From: Laura Gibbons <Laura.Gibbons@arun.gov.uk>
Sent: 27 April 2021 13:09
To: Planning.Responses <Planning.Responses@arun.gov.uk>
Cc: Anita Gardner <Anita.Gardner@arun.gov.uk>
Subject: RE: Planning Consultation on: WA/24/21/DOC

Condition 3- surface water drainage design

Application No: WA/24/21/DOC
Registered: 24th March 2021
Site Address: Lower Farm Yapton Lane Walberton BN18 0AS
Description of Works: Approval of details reserved by condition imposed under ref WA/62/20/PL relating to Condition Nos 3 - surface water drainage, 4 - discharge flows to watercourses, 5 - maintenance & management of surface water drainage, 6 - hard & soft landscaping, 7 - Construction Management Plan, 8 - ecology, 12 - cycle parking, 13 - archaeology, 16 - contamination and 17 - verification report.

**PERMEABLE BLOCK PAVING YARD CONSTRUCTION
WITH VOIDED SUBBASE AND FILTER DRAIN**
(Scale 1:20)

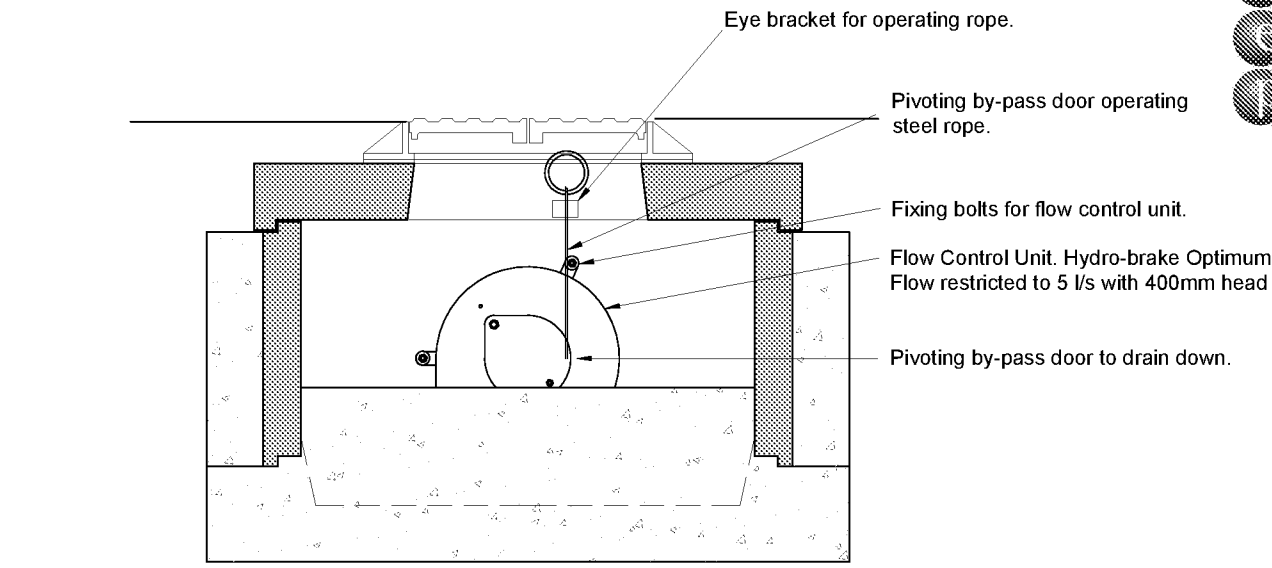
7. Finish and formation levels of permeable paving must be provided on plan.
8. Details of the proposed ditch need to be supplied, including proposed invert level, existing levels of the ditch, proposed connection invert level, long sections, cross sections.

HYDROBRAKE MANHOLE DETAIL
(Scale 1:20)

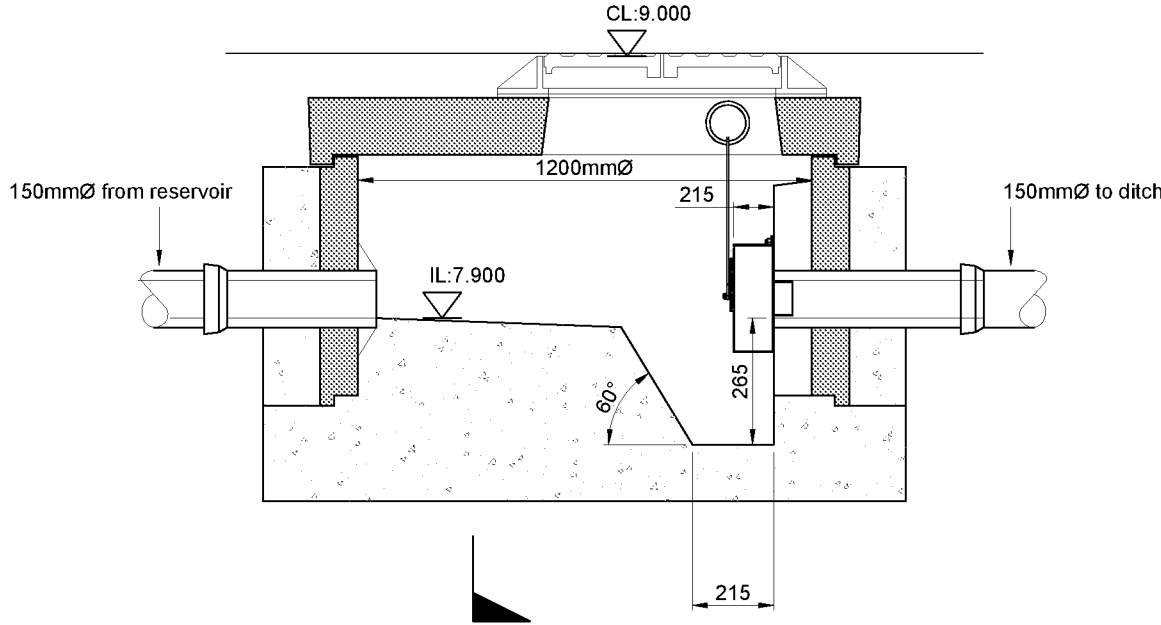
5. The construction detail of the hydrobrake needs to be updated to be consistent with layout and calculations.
6. The invert and cover level of the hydrobrake should be stated on plan.
